Re: Status of Improvement Permit Application #18-5-43196

Andrew Currin, R.E.H.S.
Environmental Health OSWW Specialist
Harnett County Department of Public Health

CS SITE PLAN
01

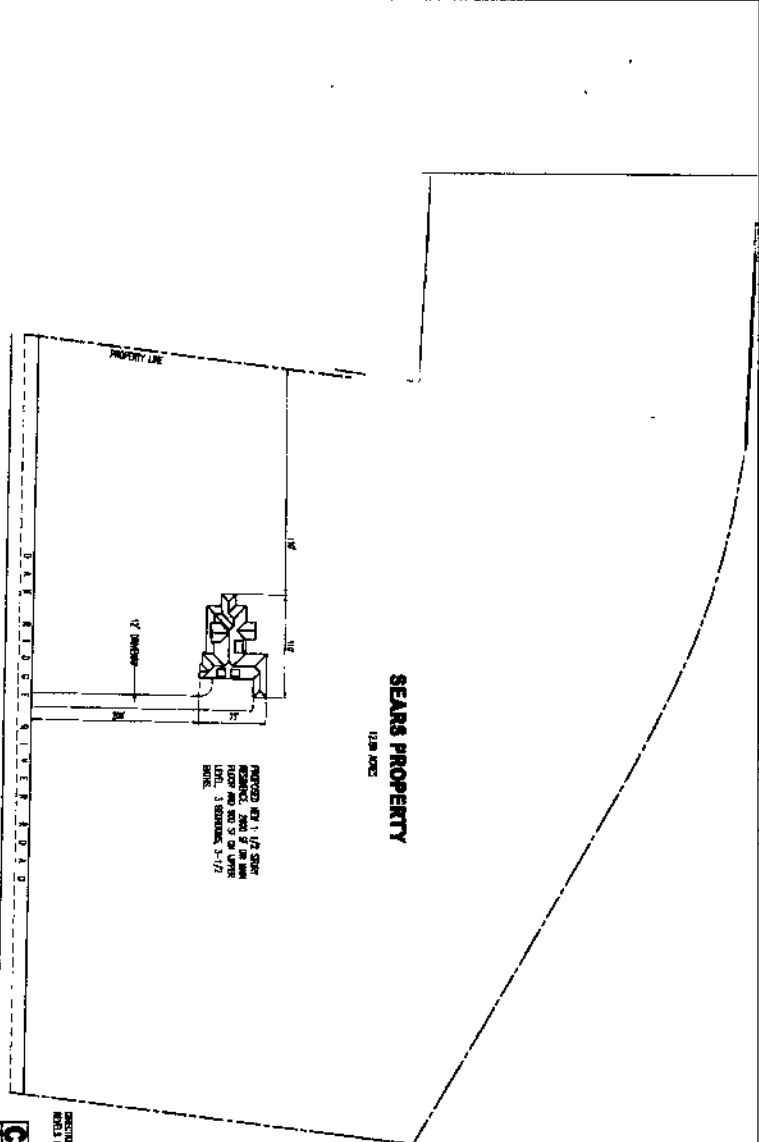
- 1. Use pink flags to mark property lines and irons that are set by surveyor need to be visible – Irons need to be displayed. (\$25.00 fee incurred)**
2. Use orange flags to mark house corners (*\$25.00 fee incurred*)
3. Directions not clear to property (*\$25.00 fee incurred*)
4. Property needs only brush or vegetation removed
5. Driveway not shown on site plan
6. Backhoe pits required
- 7. Other – Side property line setback required. Submit as a revision to Central Permitting.**
